**Subject:** Rezoning Petition Review

**Date of Review:** April 28, 2022 (*Revised June 24, 2022*)

**Rezoning Petition #:** 21-257

**Location of Property:** Approximately 52.67 acres locate on the west side of Amos Smith Rd and southeast side of Old Dowd Rd, west of I-485.

Conceptual Site Plan

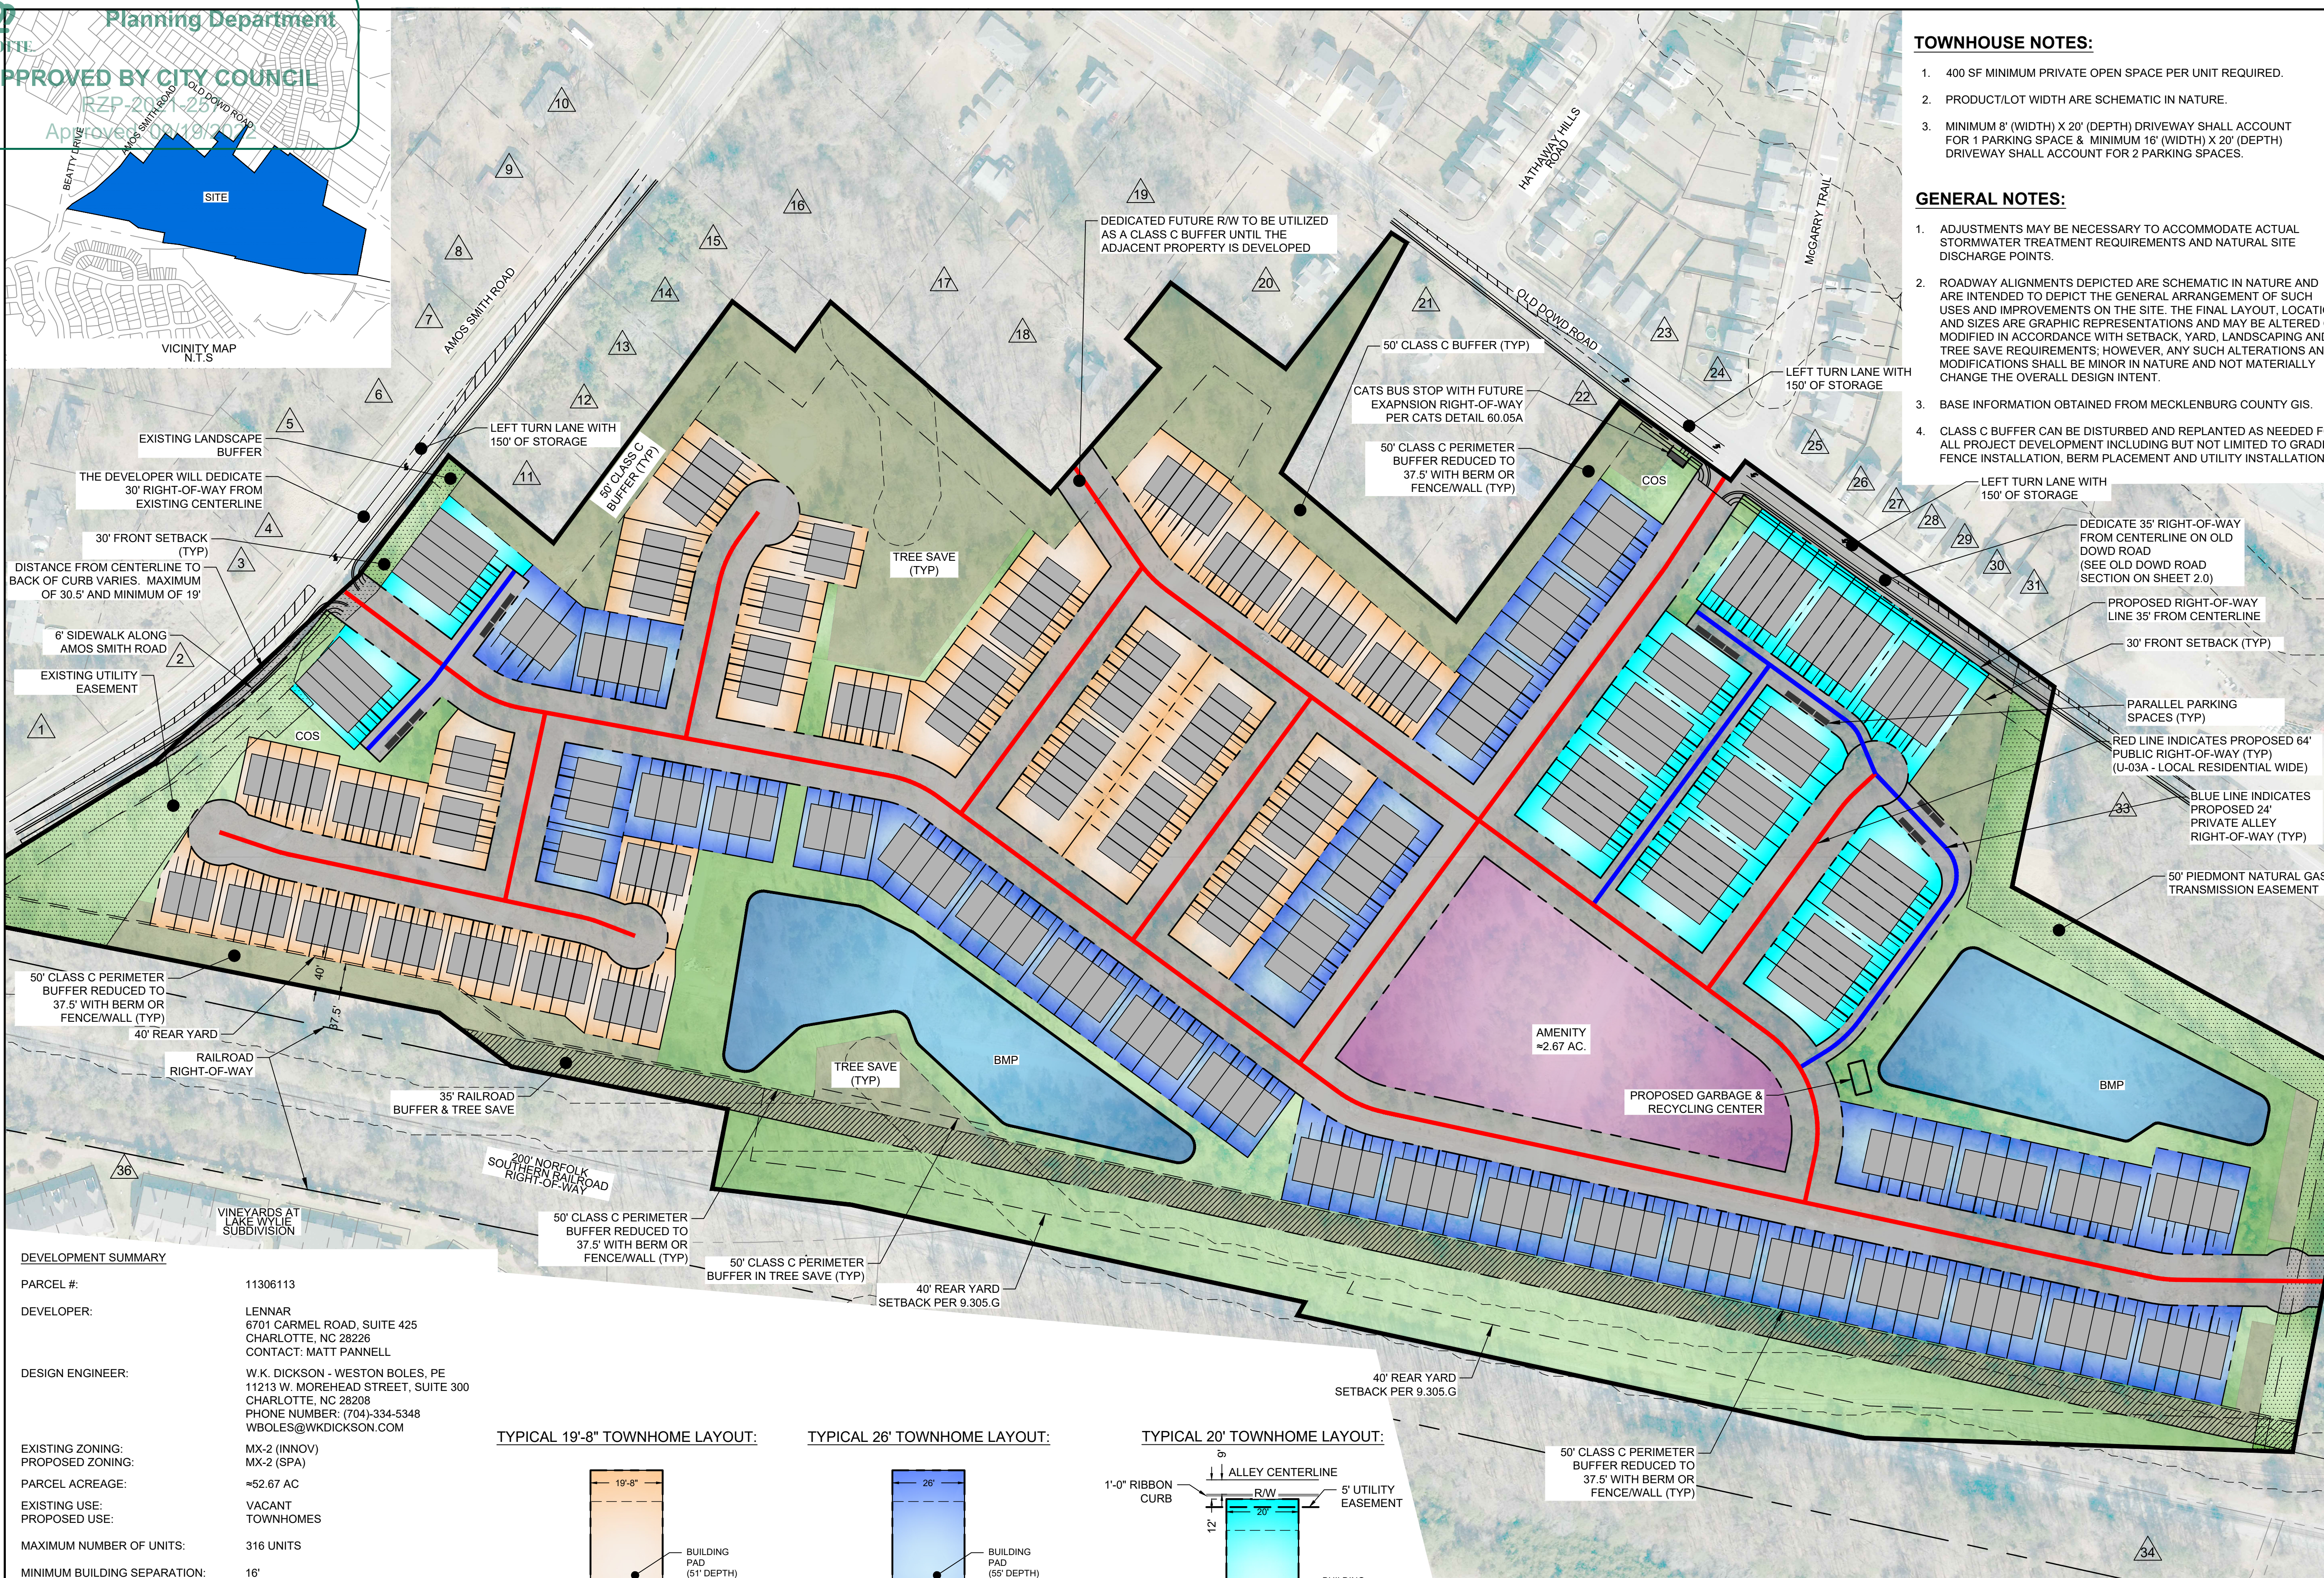
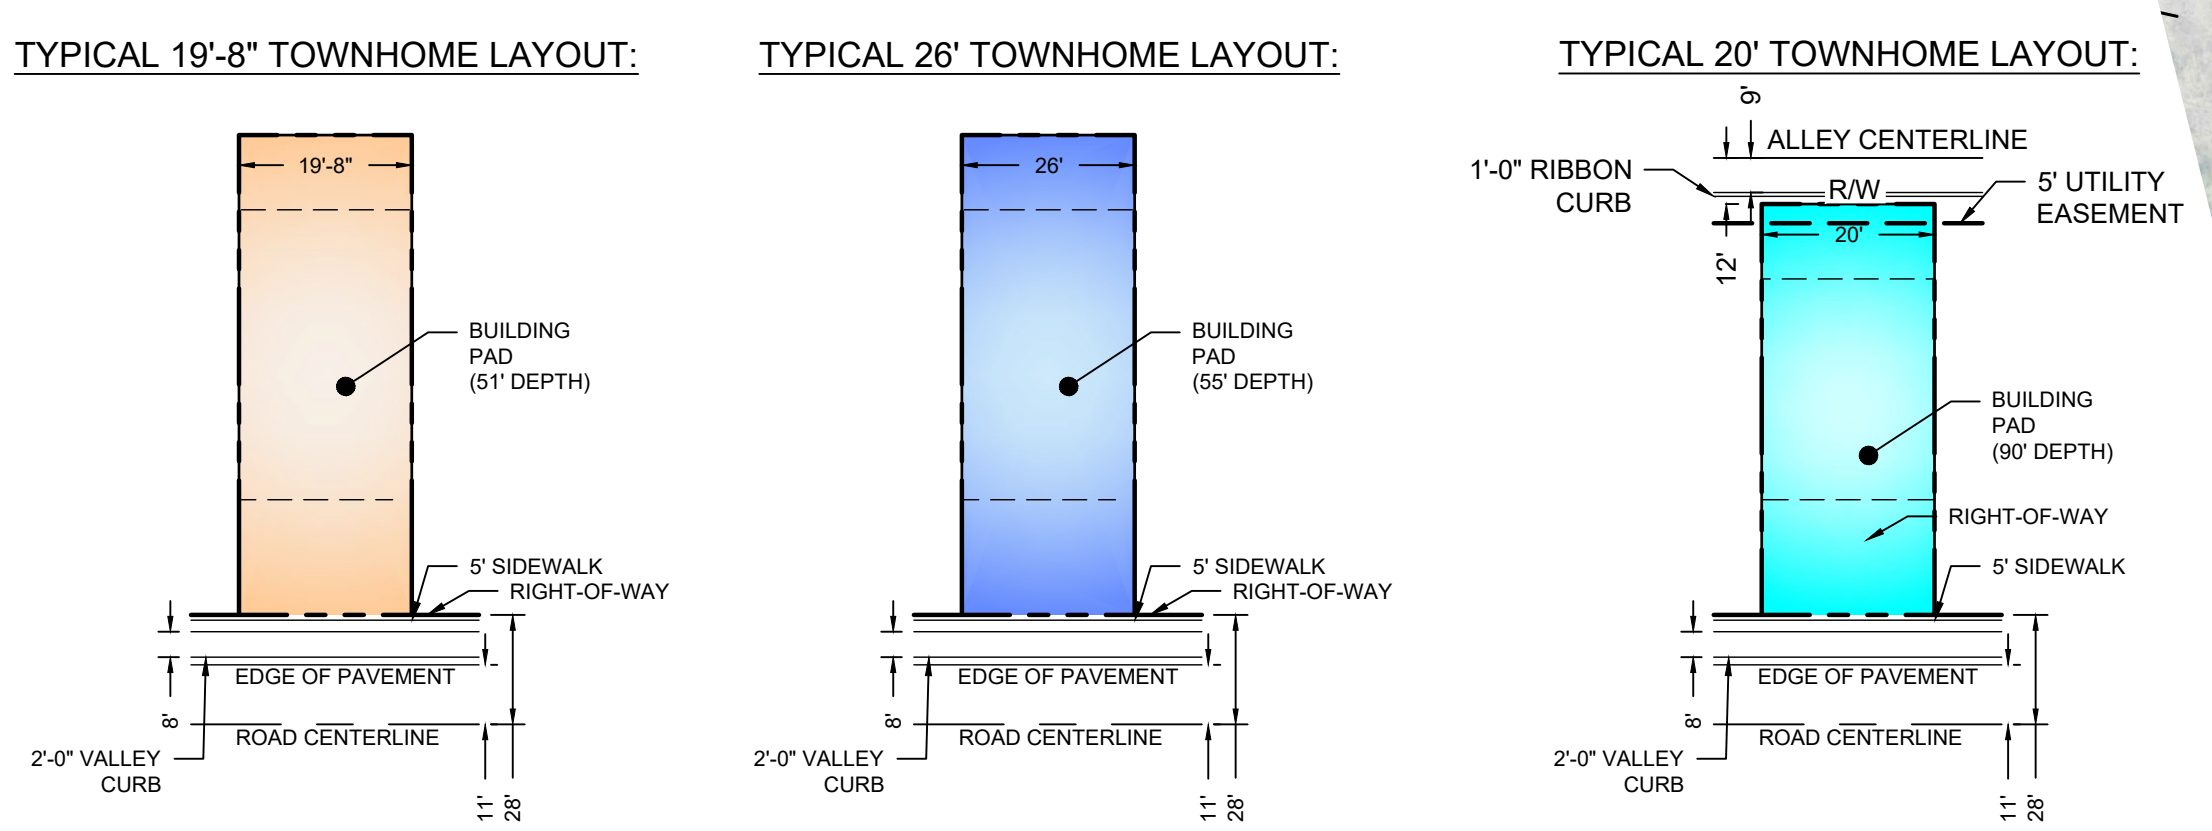
Revised rezoning sheet 1.0 has removed a potential 30-ft PCSO buffer from the plan and now indicates several building structures within the limits. Please show this 30-ft PCSO buffer on the plan sheet and include the following note under Environmental Features: *“Development within any SWIM/PCSO Buffer shall be coordinated with and subject to approval by Charlotte-Mecklenburg Storm Water Services and mitigated if required by City ordinance. Petitioner acknowledges intermittent/perennial stream delineation reports are subject to review and approval upon submission of development plans for permitting and are not approved with rezoning decisions.”*

Please note the potential PCSO buffer still does not show on the site plan. No additional recommendations are needed at this time due to the addition of the previous comments.
